Response to Submissions

SSD - 100006957

Built-to-Rent SSD – Chatswood 'Dive Site'

26 June 2026

Image 1: Pedestrian Wind Comfort Conditions without the inclusion of Landscape

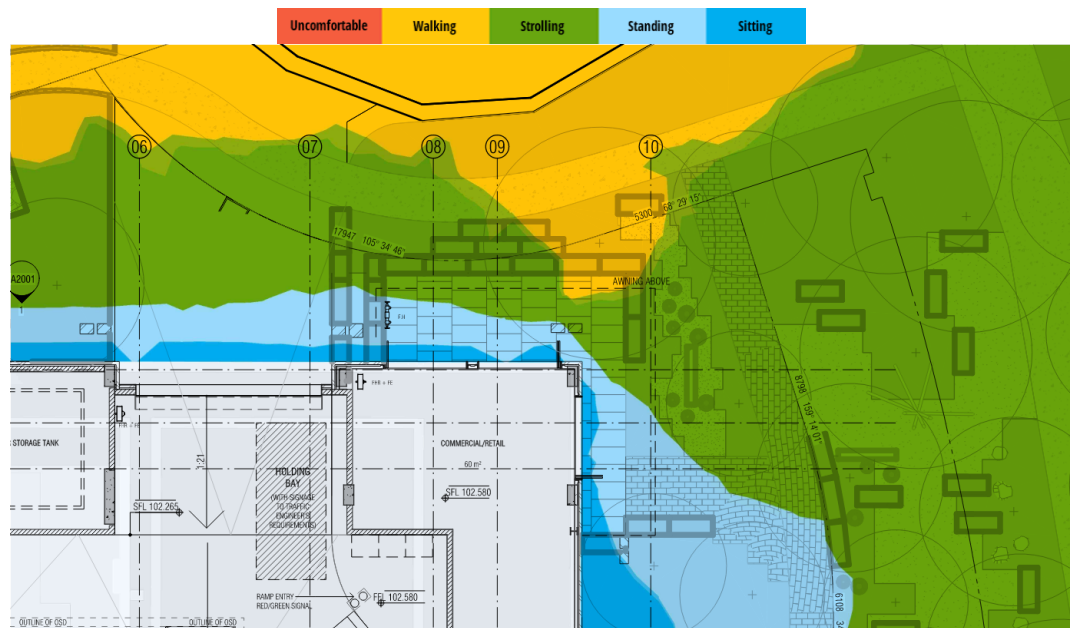
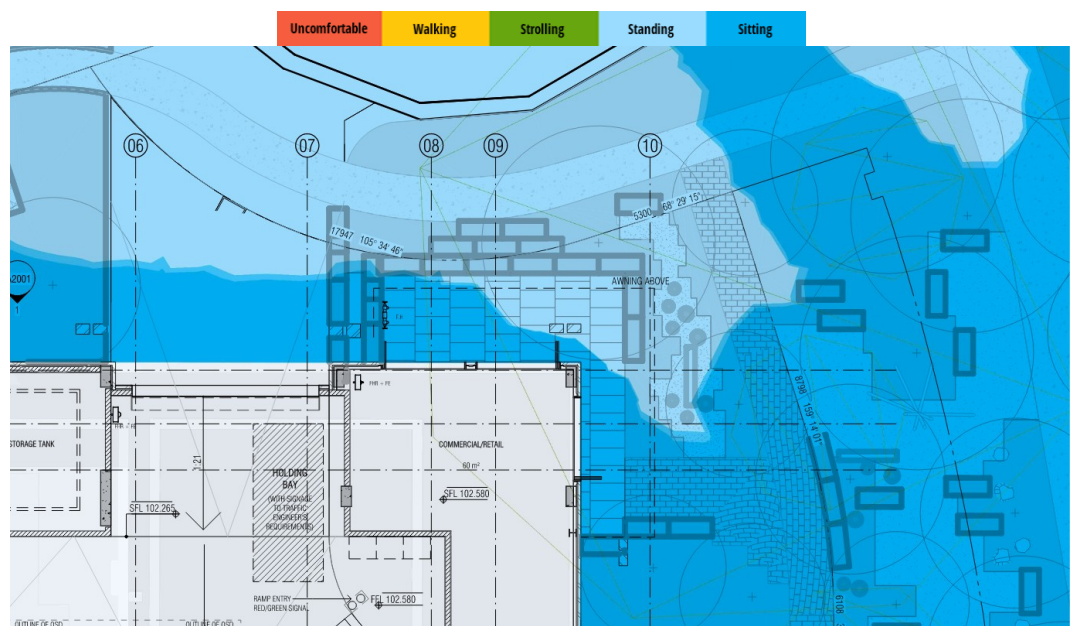
Wind Impacts	
The Pedestrian Wind Assessment does not adequately address the north-east corner of the site, which is proposed to accommodate a retail spill-out zone and play area, yet is identified as unsuitable for seating. While the report concludes that all ground-level areas will be suitable for their intended uses, this is contingent on substantial tree planting across the site.	The updated Pedestrian Wind Assessment confirms that the site prior to substantial tree planting across the site are not expected to create an unsuitable environment. RWDI confirm that the surrounding typical height of the neighbourhood buildings is between 1-3 storeys and no significant structures exist close to the site that will considerably alter the local microclimate. The existing street trees are also expected to further diffuse the winds leading to conditions that are generally expected to be suitable for passive use throughout the year. Wind conditions exceeding the safety criterion are also not expected. A letter prepared by RWDI (Appendix 8) confirms that Wind conditions are expected to range from sitting to standing use within most of the retail spill-out zone and increase to strolling and walking use conditions moving away from the corner and within the play area. It is noted that the wind impacts within the play area are considered appropriate for the intended use of the space

Council Comment / Issue	Response
	without mitigation. However, conditions within the seating areas are generally above the target sitting criterion. Further analysis of wind flows indicates that wind impacts around the corner are governed by surface-level winds from the west flowing along Nelson Street and southerly winds channelling through the play-area.

6. Further information is required to demonstrate how the proposed tree planting, at the time of the Build-to-Rent (BTR) site commencement, will achieve the necessary wind mitigation outcomes to support the intended use of these spaces.	The letter (Appendix 8) further confirms that with the inclusion of the BTR landscaping, the overall wind environment is predicted to improve substantially compared to the baseline scenario with all areas noted to be suitable for sitting to standing use.

Image 3: Proposed Landscape Design (Source: Oculus)

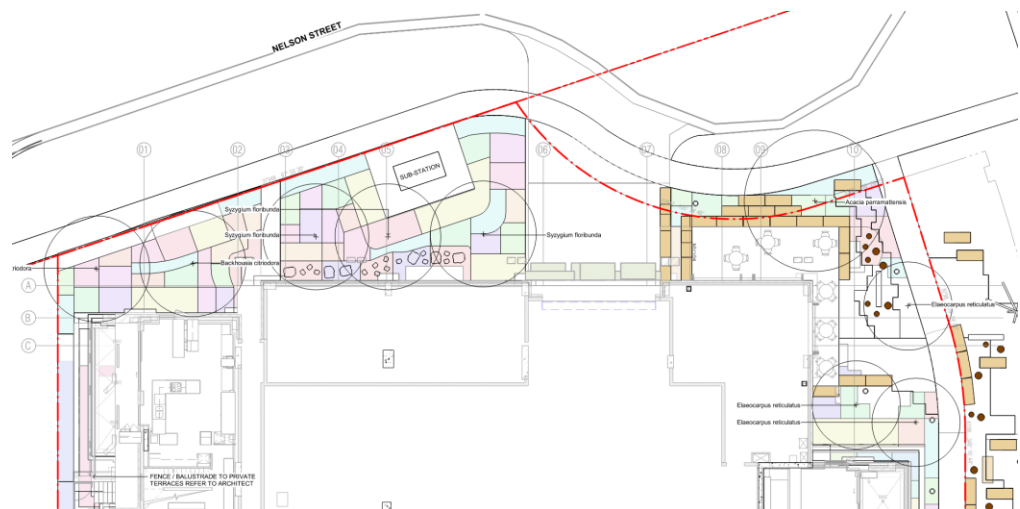
7. Provide updated landscape plans illustrating the proposed ground plane landscape treatment, including the planting of trees at the commencement of the BTR site.	Appendix 8 confirms that additional wind mitigation measures are generally not required due to the improved wind environment, however slightly elevated winds at the corner of the retail spill-out zone (approaching standing use) have been considered further through a review of the updated Day 1 landscape design. Therefore, the review of proposed Day 1 landscape design is expected to further improve the local wind conditions around the north-east corner of the development and is expected to enable the space to achieve the target criteria for both the spill-over zone and the play-area.
Overshadowing	
Provide a quantitative solar access analysis assessing overshadowing impacts from the BTR tower on the future central public park adjoining to the south and Mowbray House, including its curtilage, within the broader Chatswood Dive Site. The analysis is to have regard to the State Design Review Panel advice regarding solar access to the future public park and include shadow diagrams at hourly intervals between 9:00am and 3:00pm during the winter solstice.	FK Architects have provided detailed shadow diagrams at hourly intervals between 9.00am-3.00pm on 21 June for 2 x scenarios. Scenario 1 includes the proposed BTR and adjoining development. Scenario 2 combines the proposed BTR, adjoining development and also potential development of adjoining sites that currently have Housing Delivery Authority (HDA) requests with the Department. Scenario 1 are the diagrams that should be relied upon as they show DAs that are either approved or currently under assessment and provide a true reflection of anticipated solar impact. Scenario 2 are considered speculative and are not certain. Despite this, the two scenarios show that between 9-10am and from 2pm-3pm mid-winter; the future central park will receive greater than 50% sunlight. Under Scenario 1 the park receives solar access for at least 40% of the park throughout the whole day in mid-winter and generally achieves 50% or more (with the exception of at 11am and 1pm). Given the urban environment in which this proposal is located, this is considered acceptable.

1 DETAILED PLAN - SUBSTATION KIOSK
1:50

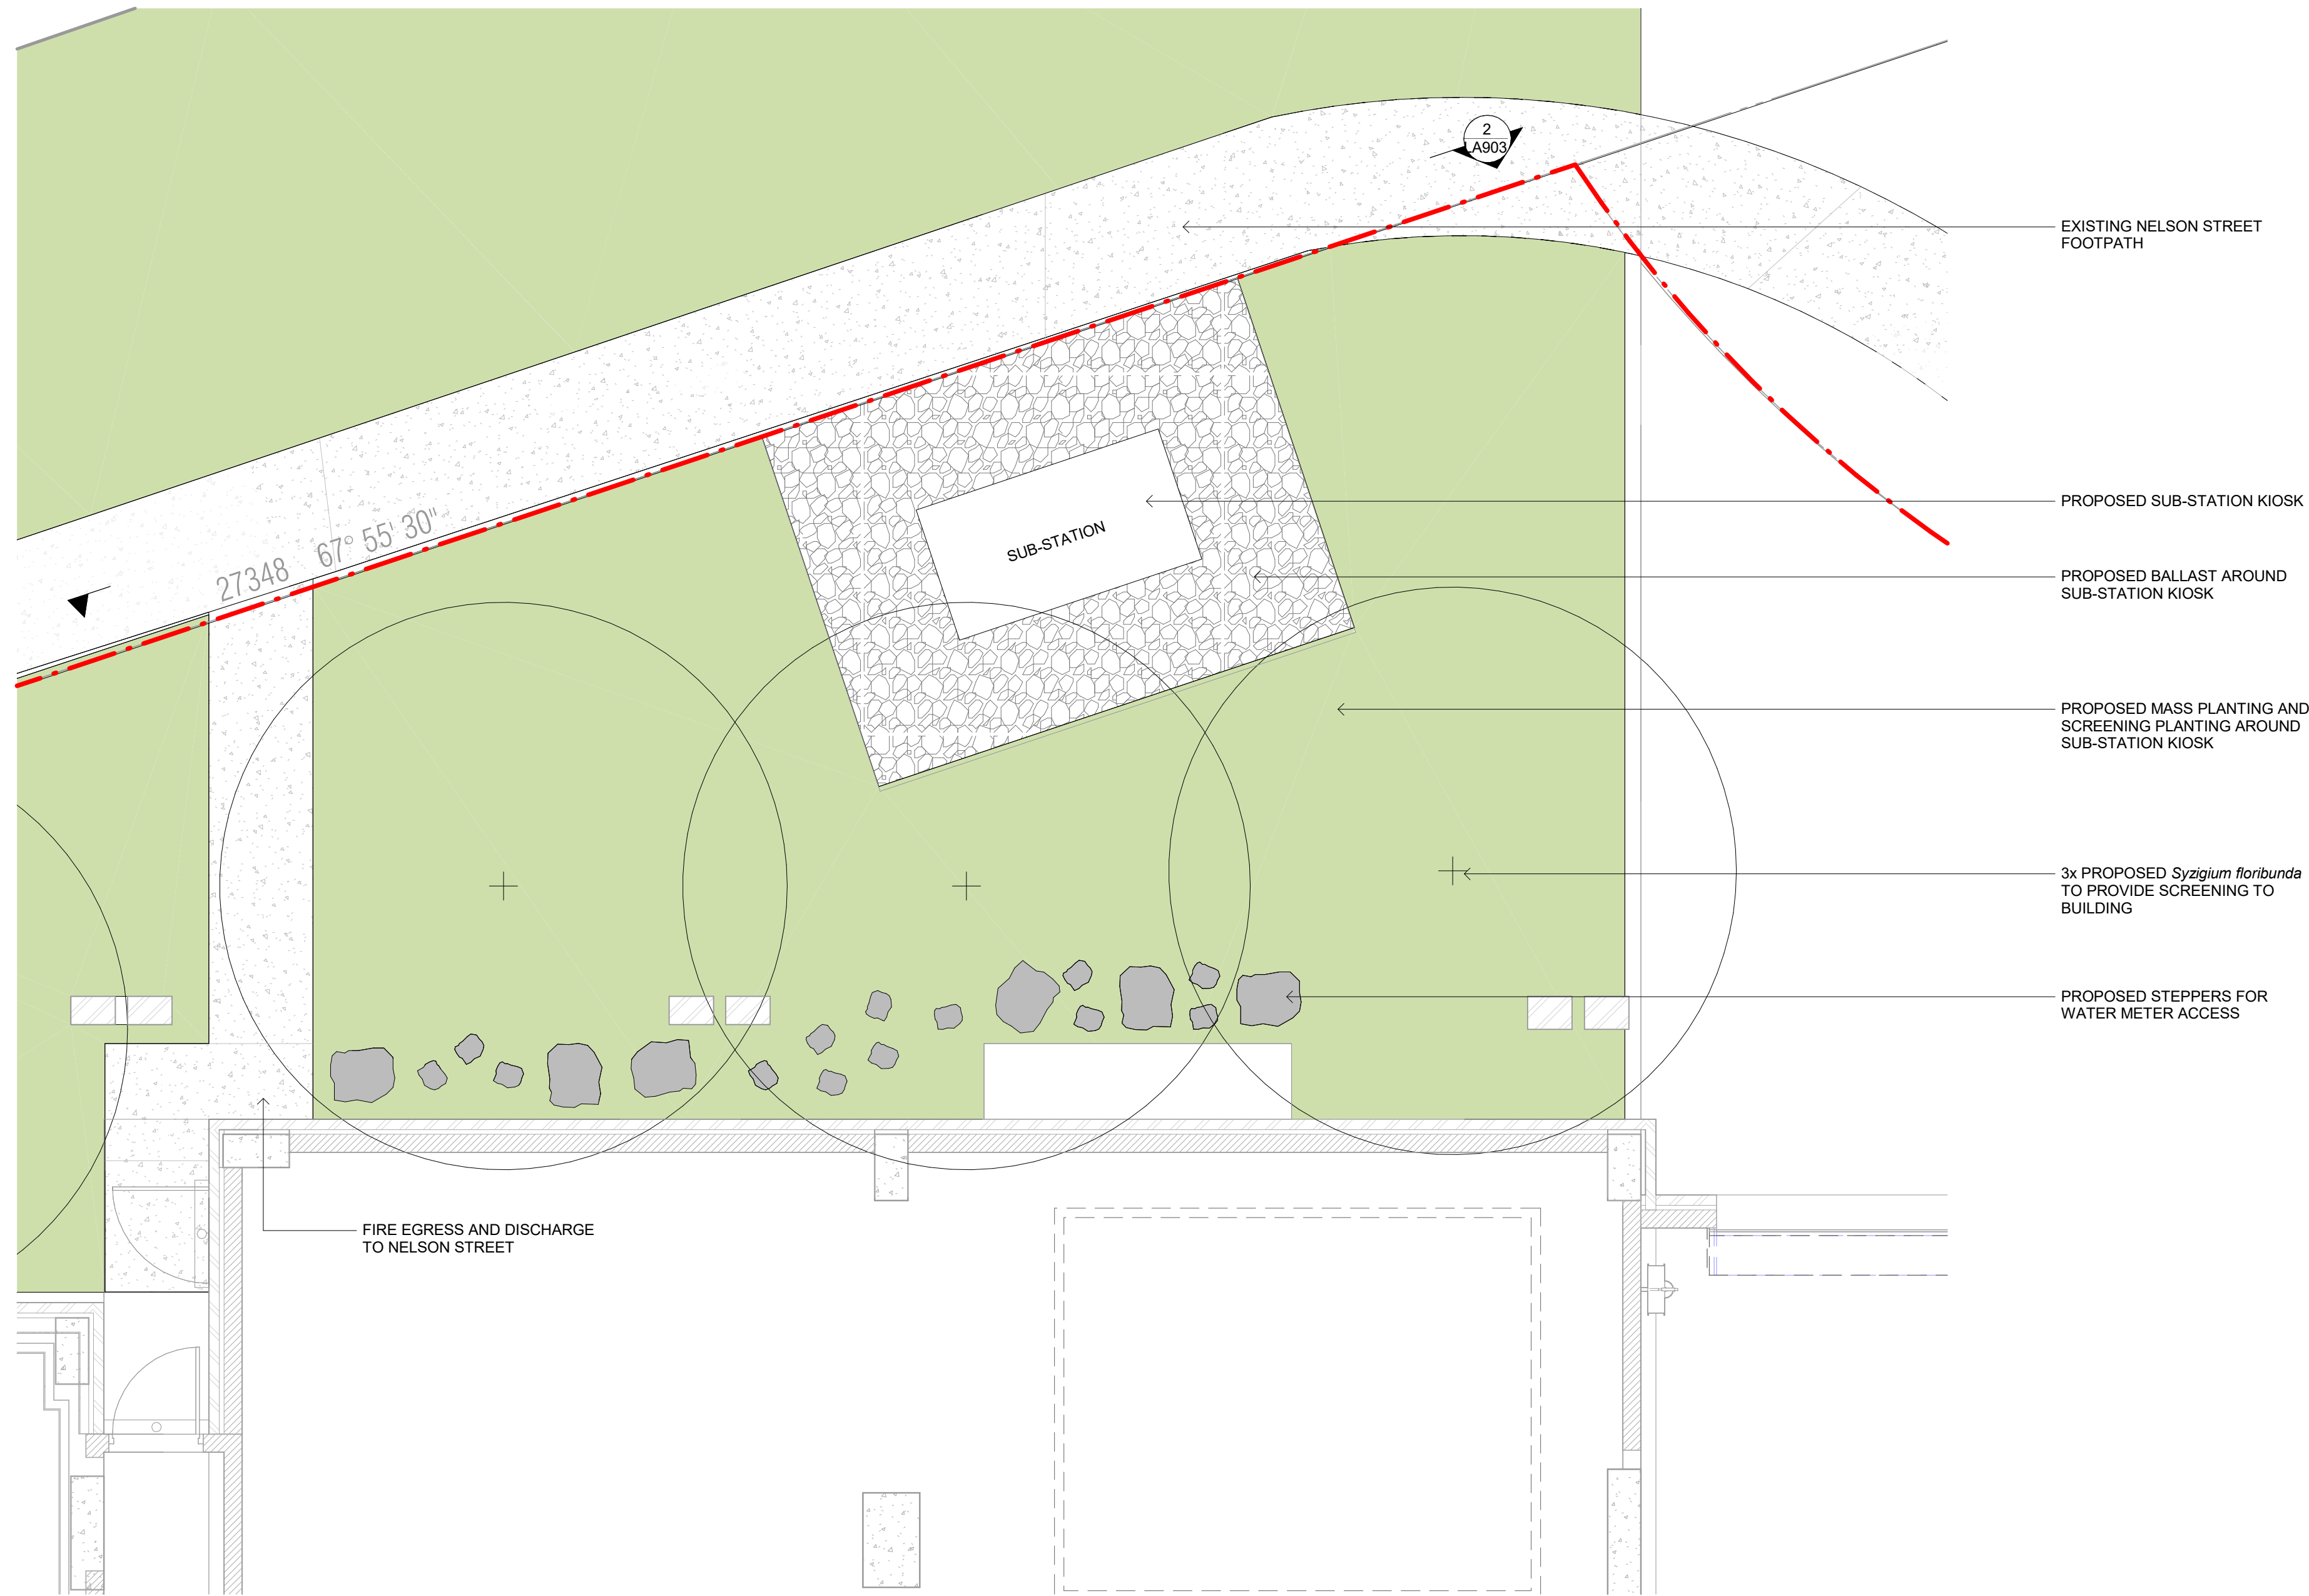
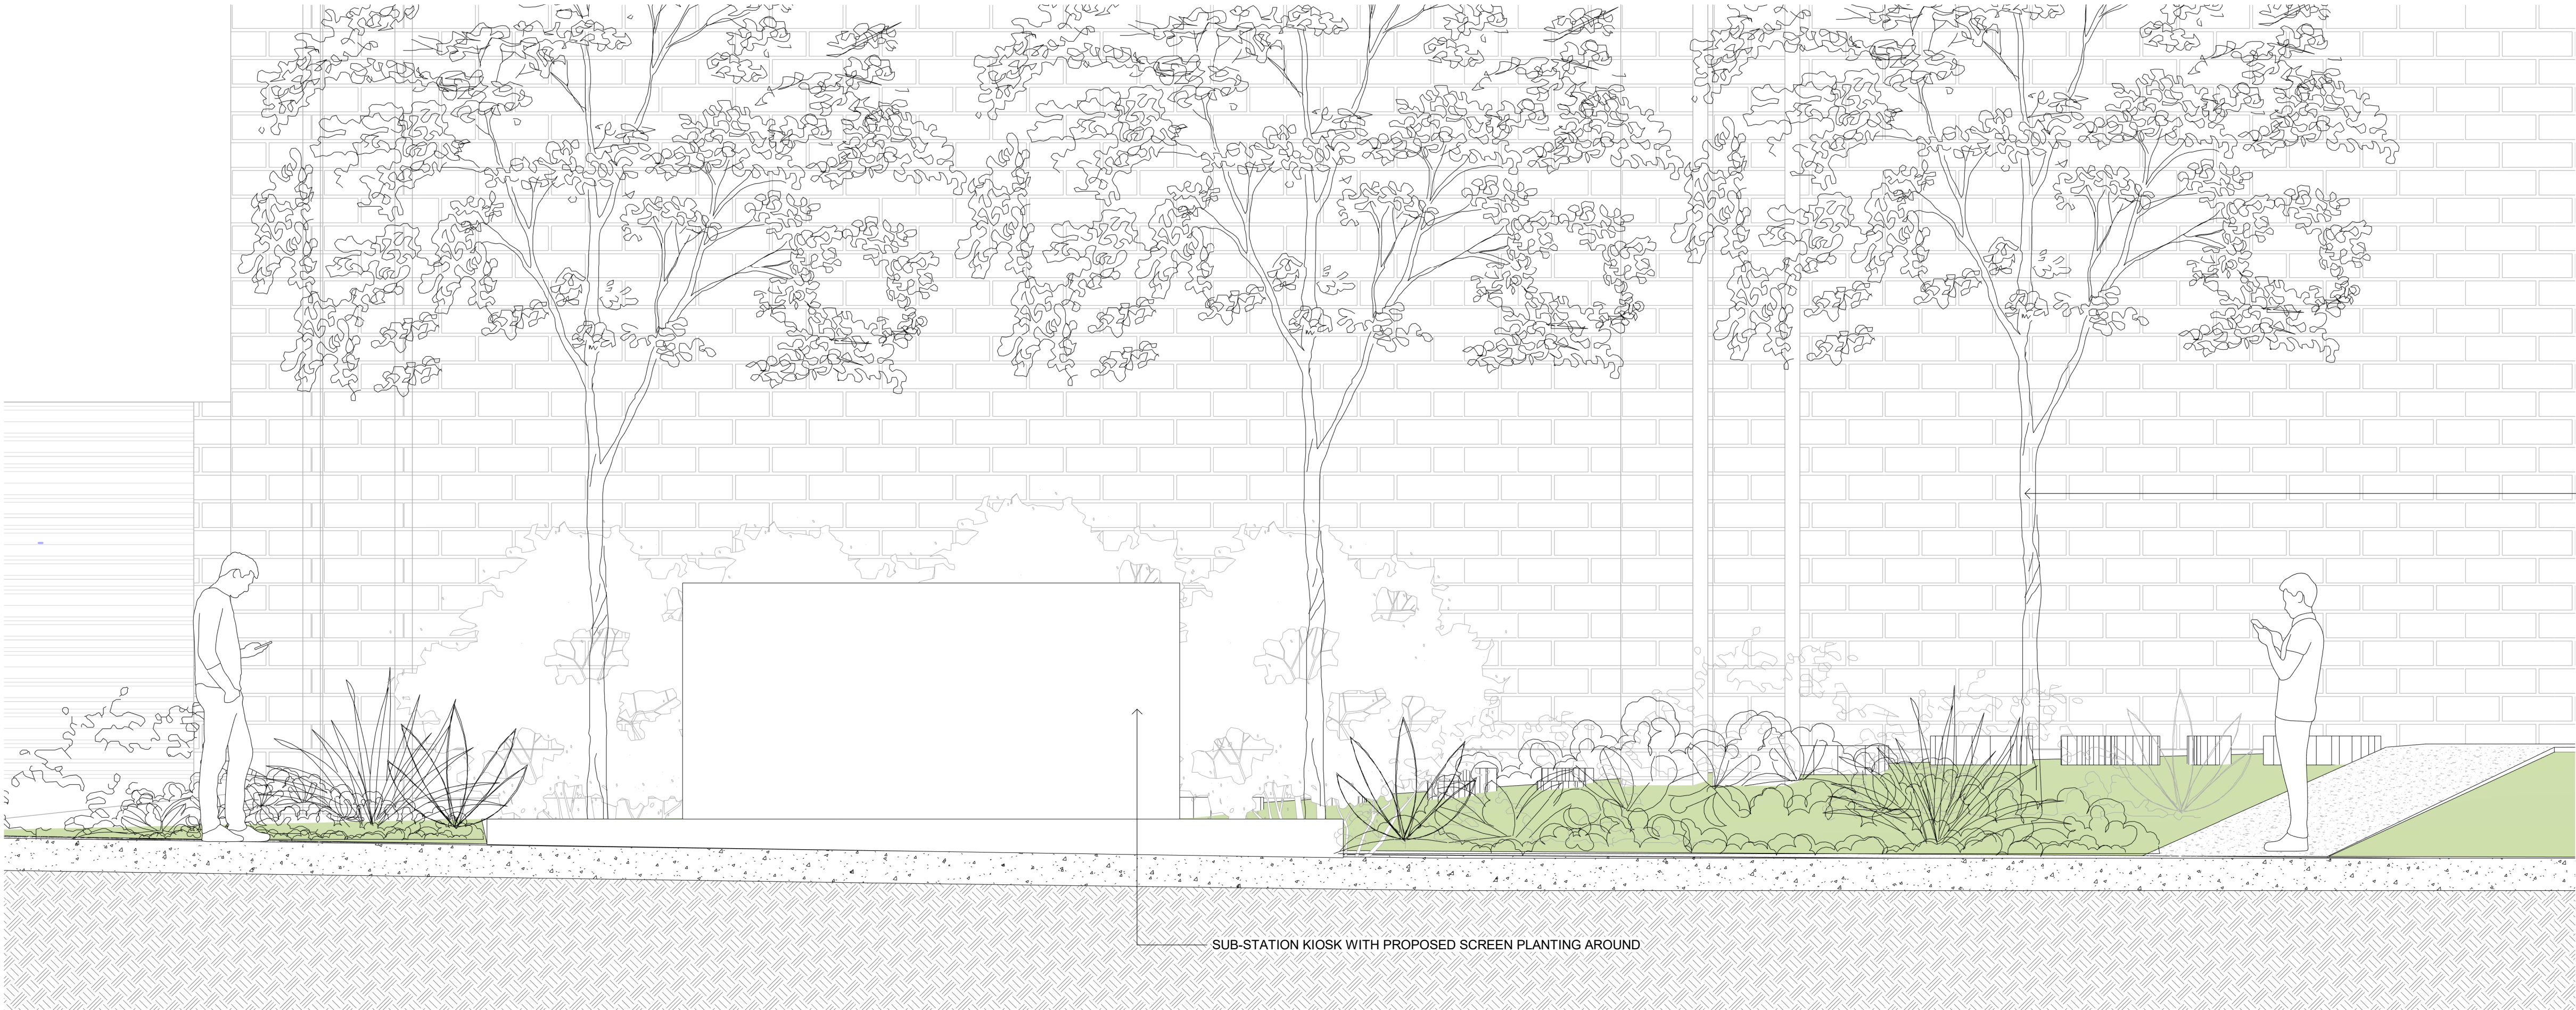
18. Provide detailed plans showing improved integration of the substation with the built form	Oculus have provided an additional detailed plan and elevation at Appendix 7 which identifies the substation.

Council Comment / Issue	Response
and landscaping to minimise its visual impact along the Nelson Street frontage of the BTR site.	Mass planting, including targeted screen planting, is proposed along the south, east, and west sides of the substation kiosk. The north side of the substation connects to the Nelson Street footpath to provide access. Trees are proposed to the south of the substation, between the building and the kiosk, to provide additional screening for residents and minimise visual impact along Nelson Street
Public Art Strategy
